May 31, 2006

**Re: 505 Second St. SW Grading and Drainage Plan**  
**Engineer's Stamp dated 5-24-06 (K14/D93)**

Re: Traffic Circulation Layout (TCL) Submittal for Building Permit Approval for  
Offices and Warehouse for 505 2<sup>nd</sup> St [K-14/D-93rr]  
(505 2<sup>nd</sup> St. NW), Albuquerque, NM  
Engineer's/Architect's Stamp Dated 05-19-2006

**Re: 505 2<sup>nd</sup> Street, Traffic Circulation Layout**  
**Architect's Stamp dated 02-16-06 (K14-D93)**

Sheet:
General Info
Site Plan

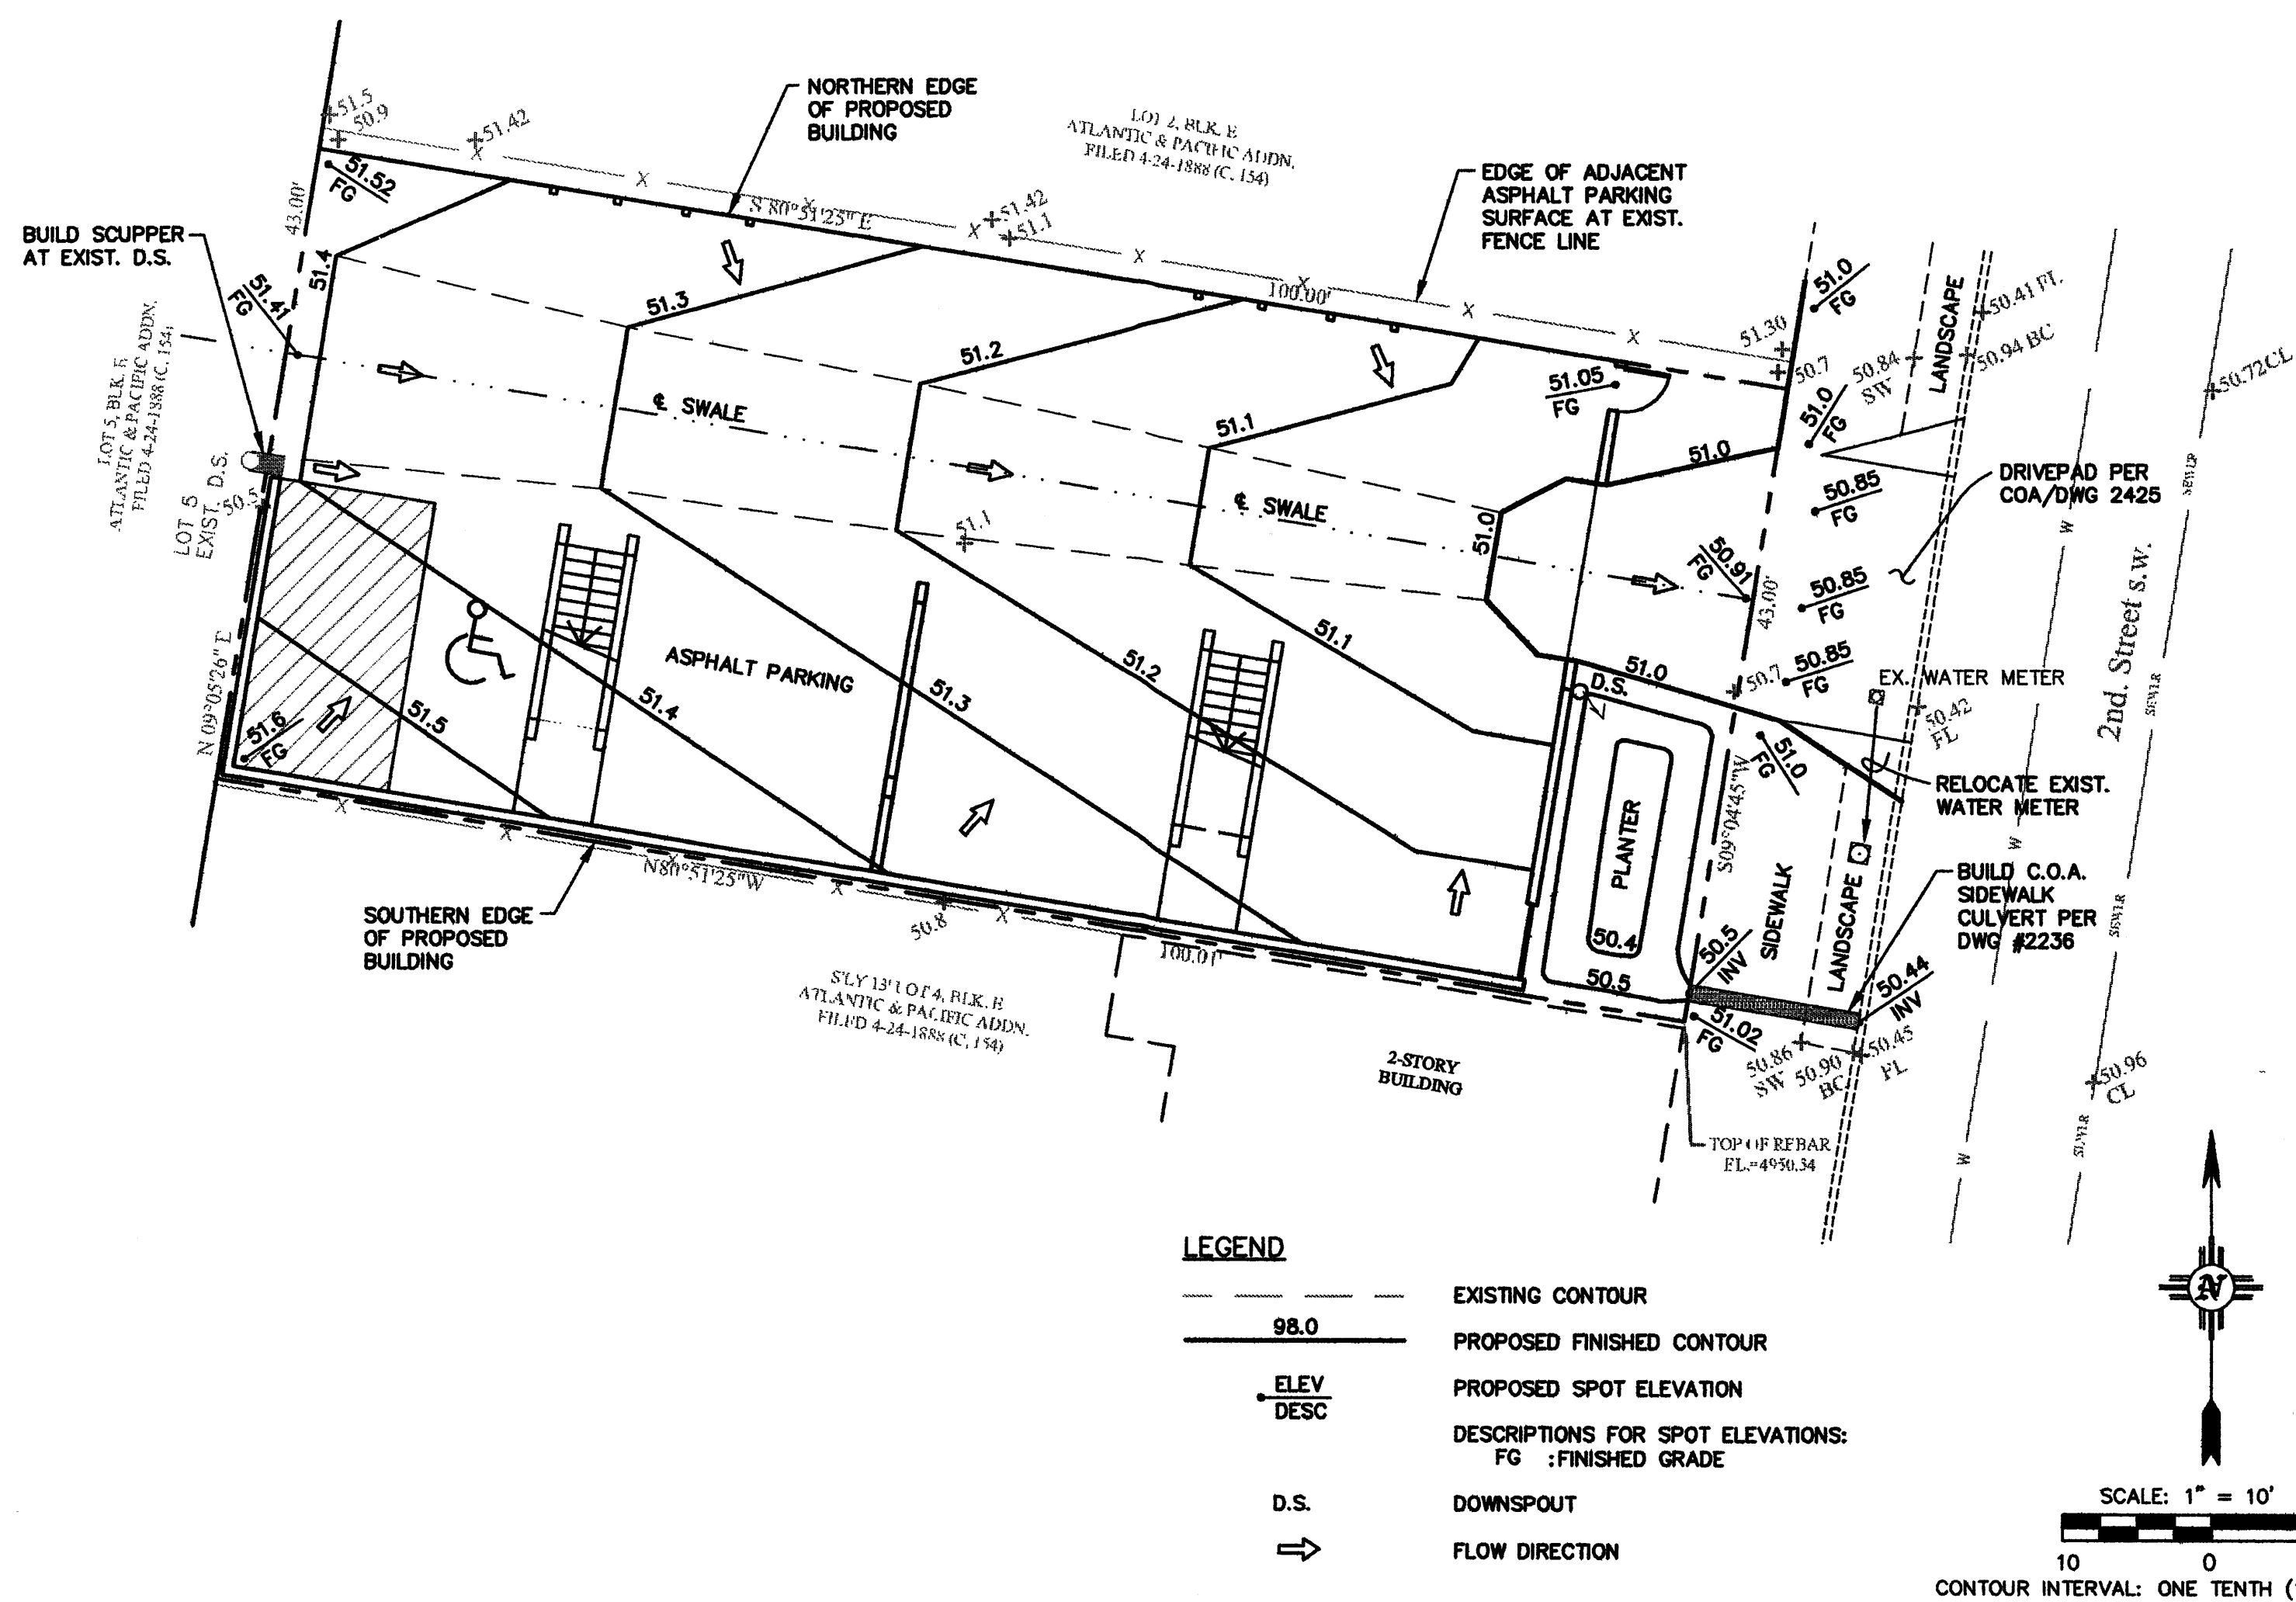
1. Provide solid waste approval.
2. Verify the width of the existing sidewalk and provide the width of the proposed sidewalk.
- 3.

1. Label the drive-pads as existing or proposed. ✓
2. Please, refer to all appropriate City Standards; the drawing number ✓ should be included in this reference. ✓
3. Include a vicinity map for the location of the project. ✓
4. Parking calculations need to be provided. 1- PER RATE - 4 REQ. 7 PROVIDED ✓
5. Label all access roads around the building. - 2<sup>ND</sup> STREET TO EAST ✓
6. Include and provide widths of all sidewalks and wheel chair ramps. ✓

Solid Waste  
APPROVAL  
SDWK  
Existing  
W7  
Verify 4-8
